**Our ref:** WA/2021/129106/04-L01  
**Your ref:** 21/01630/OUT  
**Date:** 09 May 2022

**Outline planning application for residential development (within use class C3), open space provision, access, drainage and all associated works and operations including but not limited to demolition, earthworks, and engineering operations, with the details of appearance, landscaping, layout and scale reserved for later determination**

**Land at North West Bicester, Home Farm, Lower Farm and SGR2, Caversfield**

Appendix A

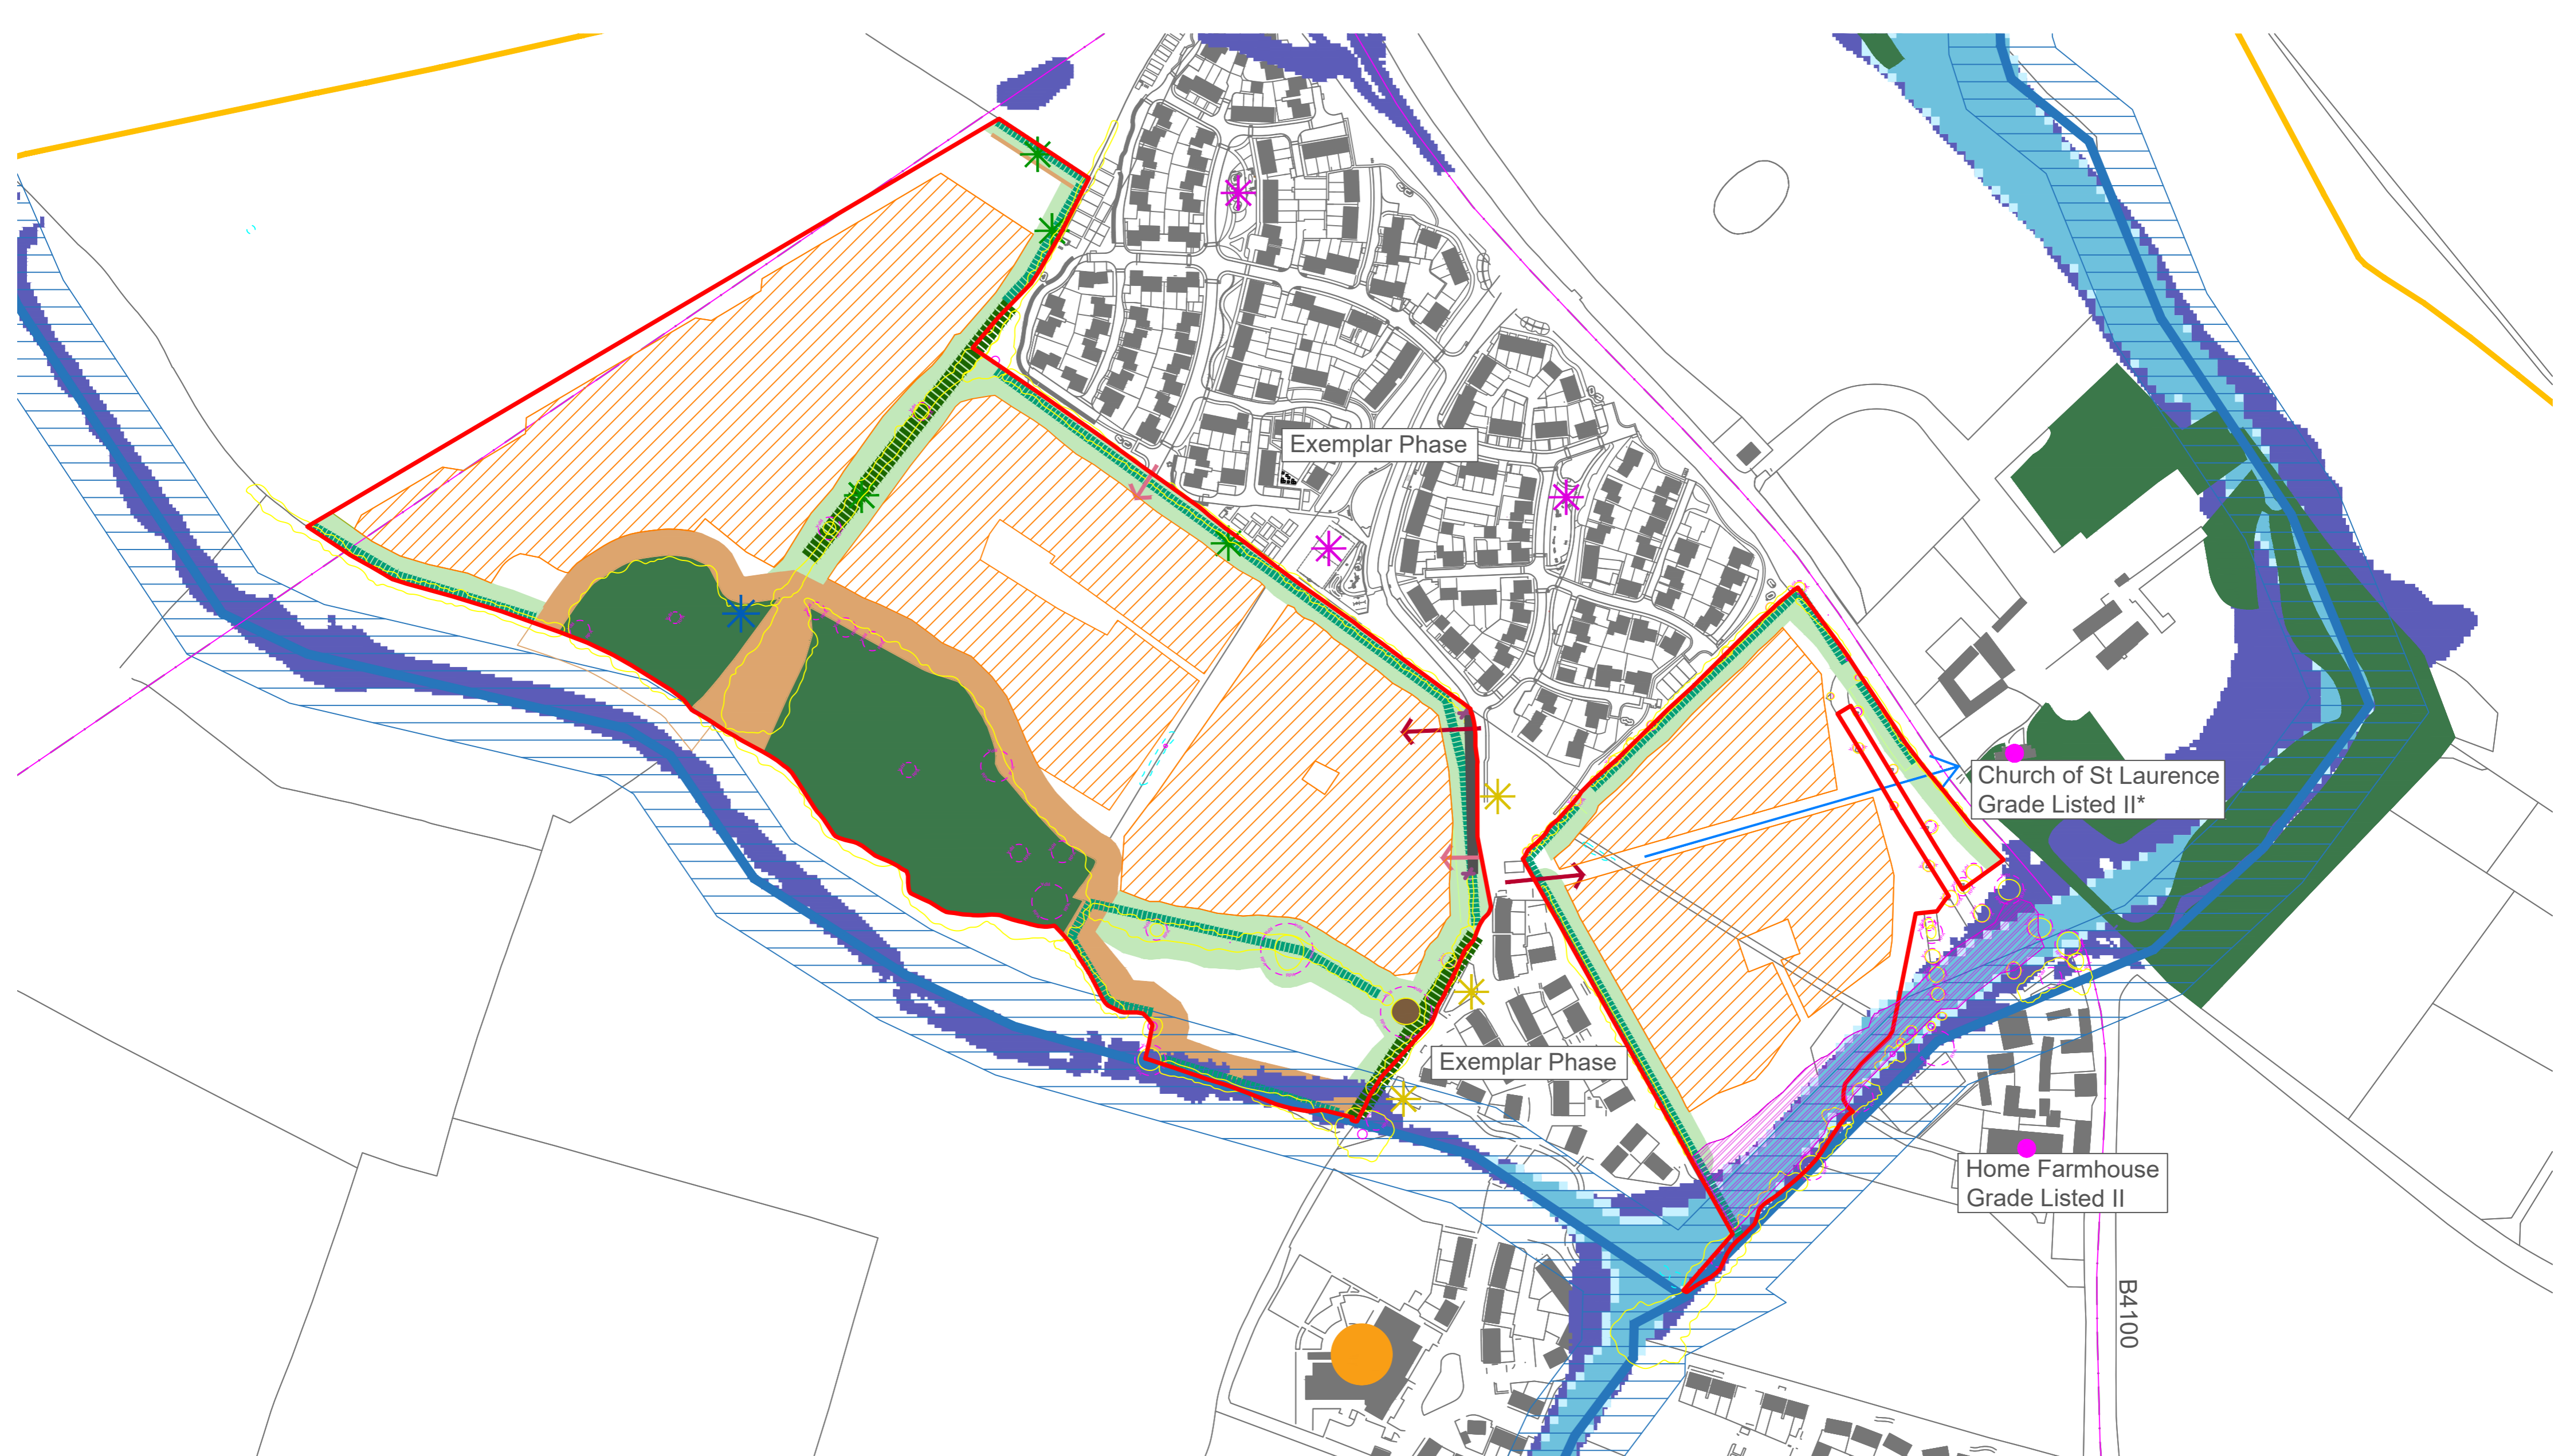
There shall be no residential development or raising of existing ground levels within the areas identified as being at risk of flooding as shown in Appendix A of letter reference L01/205550D/NB dated 04 February 2022, from Vectos Limited.
